## ENVIRONMENT AGENCY

### WRITTEN REPRESENTATION

#### HIGHWAYS ENGLAND'S RESPONSE

*Deadline 4 (26 November 2015) – Written summaries of oral submissions presented at issue specific hearings on 17, 18 and 19 November 2015. Development Consent Order Application M4 - Junctions 3-12 (Smart Motorway)*

| 514451-MUH-00-ZZ-DR-DR-400156 | 11 |

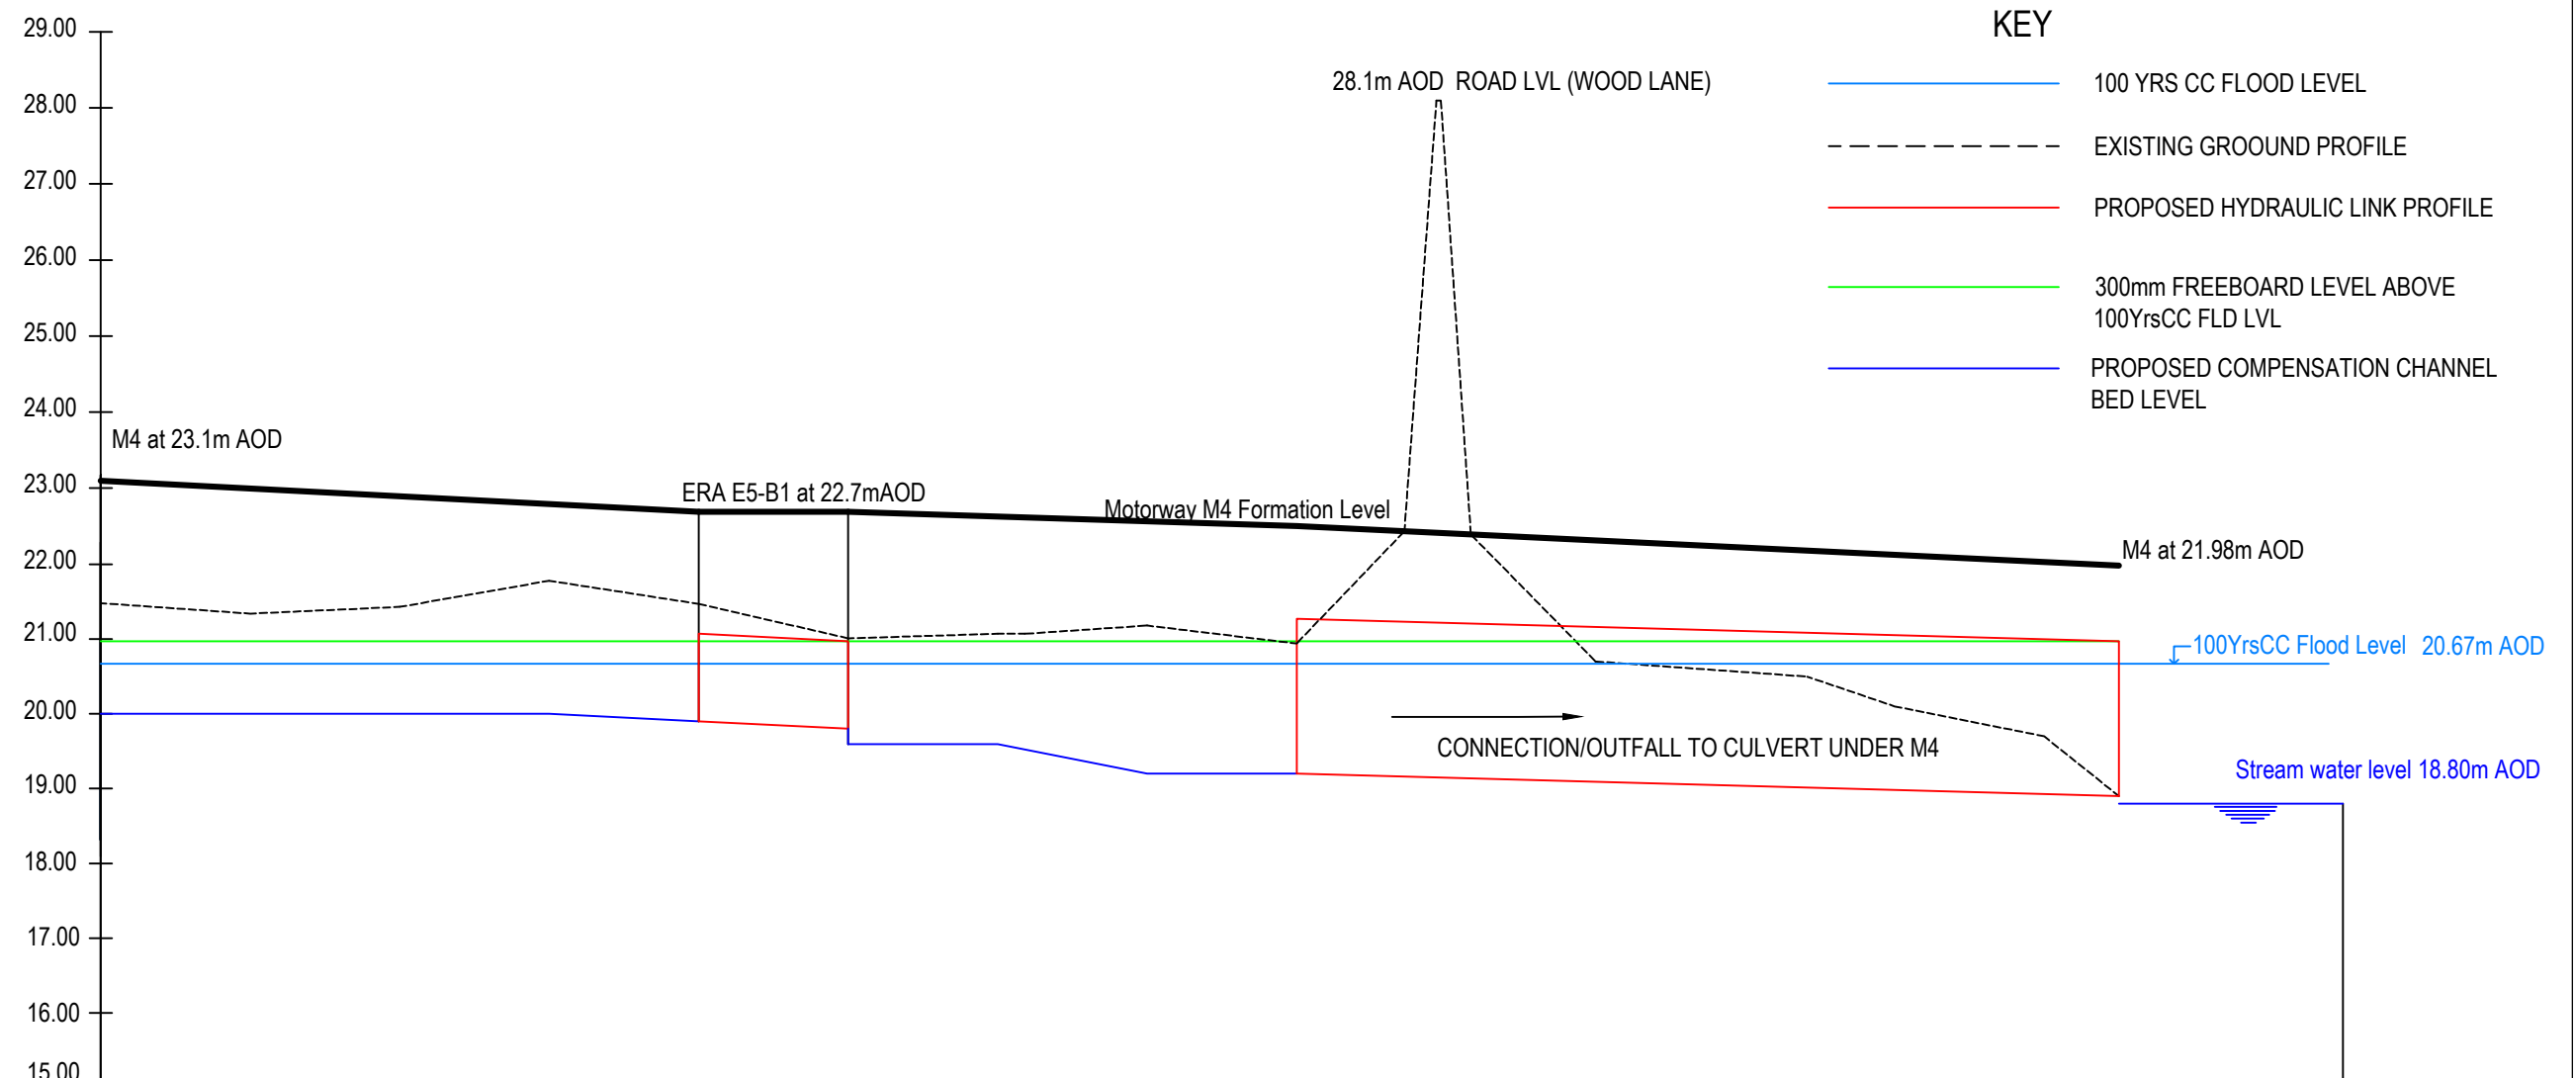
1.19 *Area R18 (WB), Junction 7-6 (CH 26500-27100) and Area R19 (EB), Junction 7-6 (CH 26550-27070), drawing 514451-MUH-00-ZZ-DR-DR-400157.*

- 1.20 *A cross section for this area has been submitted, which supports the written summary of compensation calculations as shown in Table 1. The invert level of the culvert is shown to be flat. Due to the length of the connectivity, we have concern about whether flood water would be able to recede back to the flood plain. There is limited information about the culvert link across the motorway is shown on the plan and how this will be used.*

- 1.20.1 Paragraphs 6.5.17 to 6.5.19 of the updated Deadline V Flood Risk Assessment provides additional information regarding floodplain compensation and hydraulic linkage at Area R18 and Area R19. The proposed hydraulic connectivity link uses pipe culverts between the floodplain and flood compensation areas located on the eastbound side of the M4 at a level of 19.2m above ordnance datum (“AOD”). A new floodplain compensation ditch on the westbound side of the M4 lies at the same level as the ditch on the eastbound side of the M4 at 20.2m AOD. Therefore, flood water will first rise within the lower eastbound flood compensation area before surcharging into the floodplain compensation ditch on the westbound side of the M4 using the existing pipe culvert crossing, as shown on flood compensation map 514451-MUH-00-ZZ-DR-DR-400157 (Annex G of the updated Deadline V Flood Risk Assessment). Flood water would then recede back from the M4 westbound side floodplain compensation area to the eastbound side floodplain compensation area, through the existing pipe culvert crossing the M4 and finally along the eastbound hydraulic link into the nearest floodplain after the flood event occurred.
